From: Laura Gibbons
Sent: 29 March 2018 10:54
To: Planning.Responses
Subject: RE: Planning Consultation on: A/36/18/OUT

Engineers comments in respect to surface water drainage:

APPLICATION **A/36/18/OUT**

Site Address: Land off Arundel Road Angmering BN16 4ET

Figure 5.2: Illustrative Masterplan.

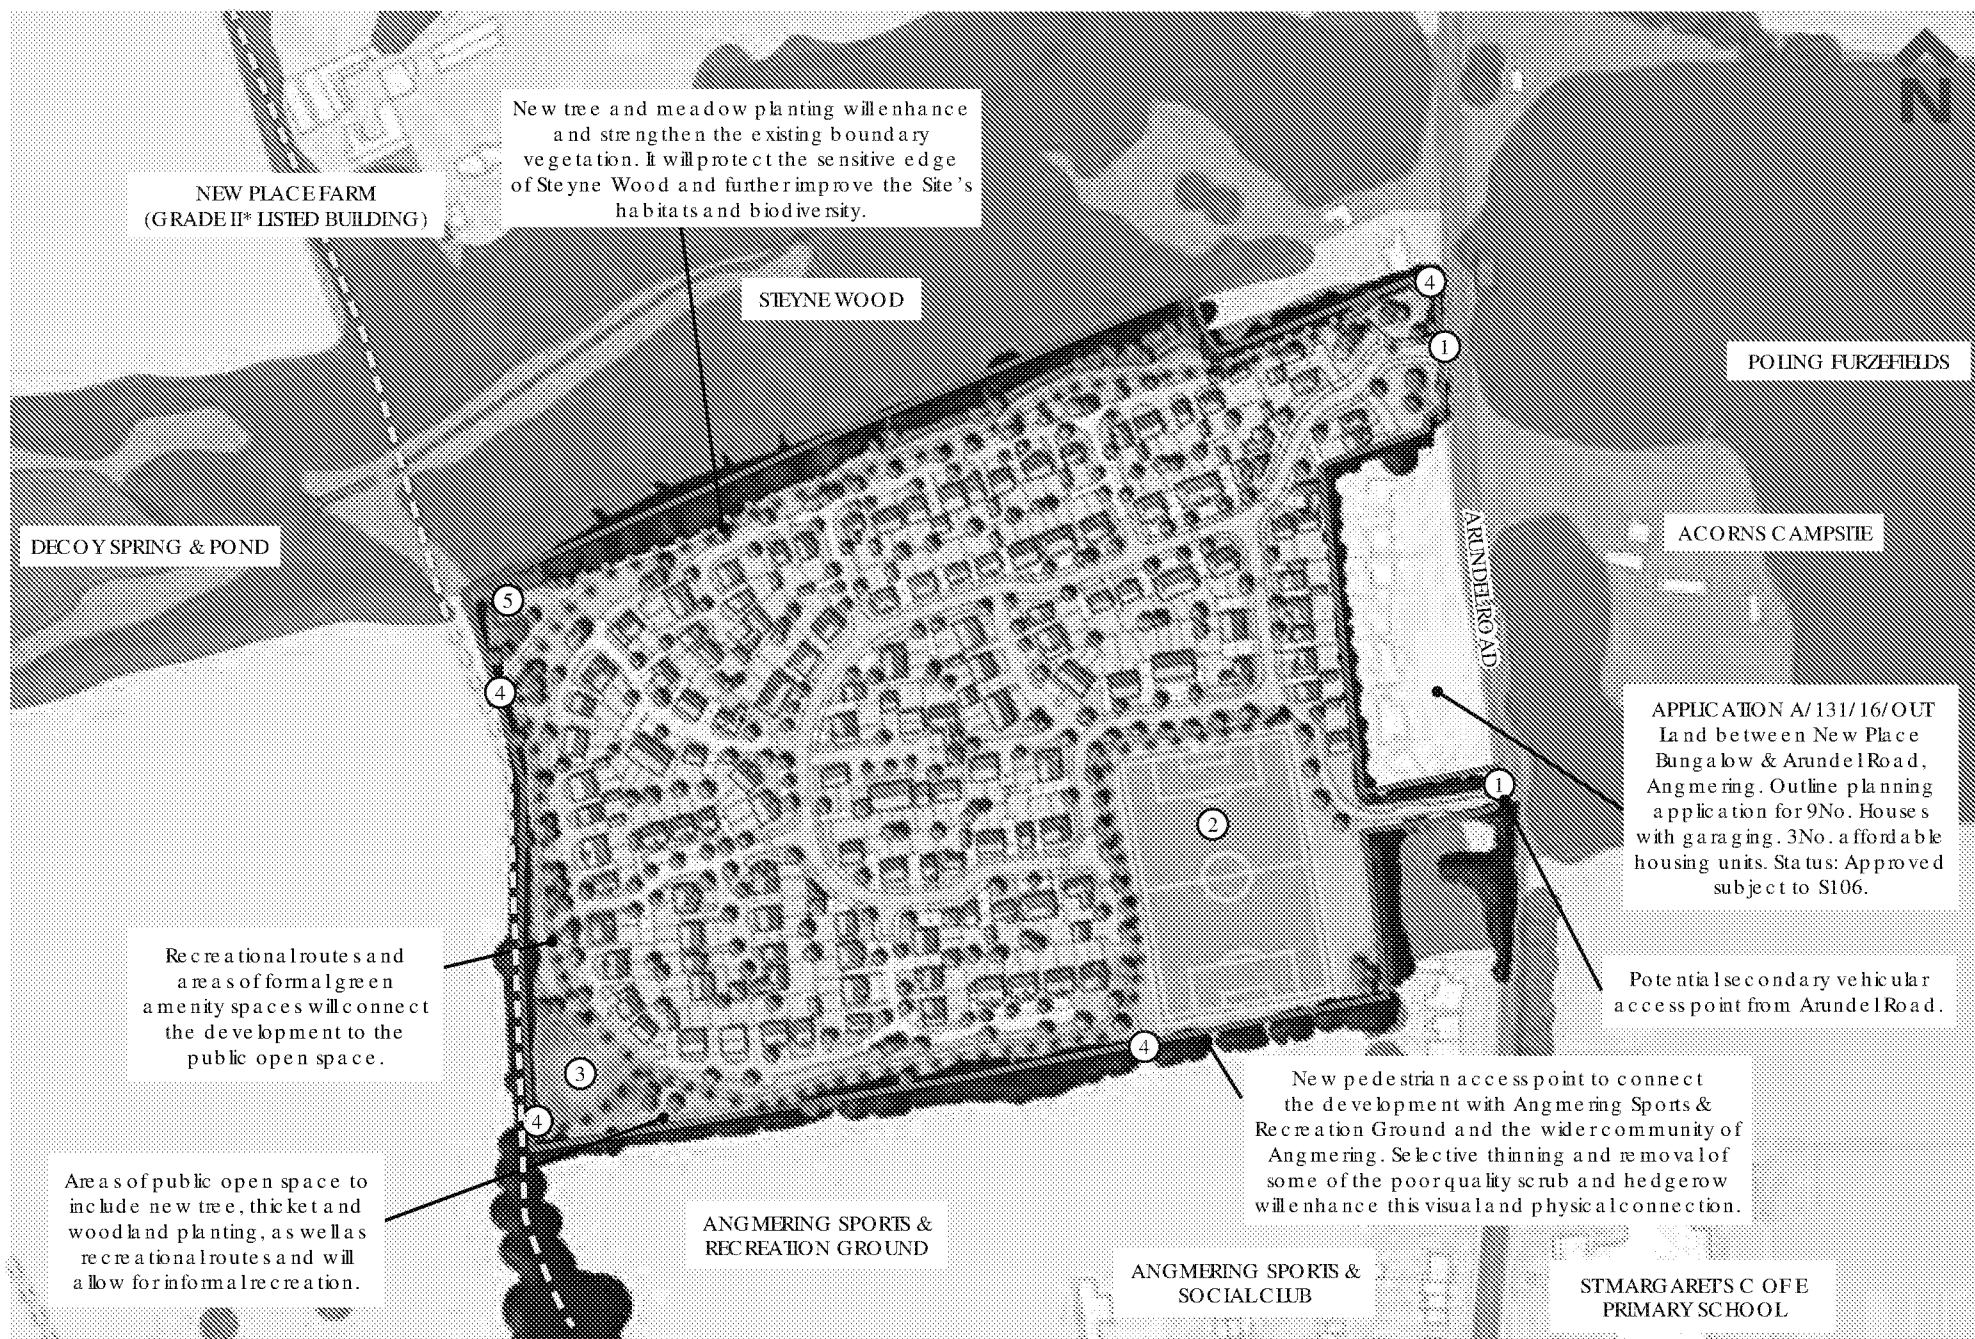
Sufficient space for SuDS will need to be incorporated into the masterplan. Development shall not commence until full drainage design has been agreed.

It is noted that a watercourse runs along the west of the site. Any proposals to alter or culvert this will require ordinary watercourse consent. And a minimum of 3m easement to the watercourse which run to the west of the site will be required to enable future maintenance of the watercourse.
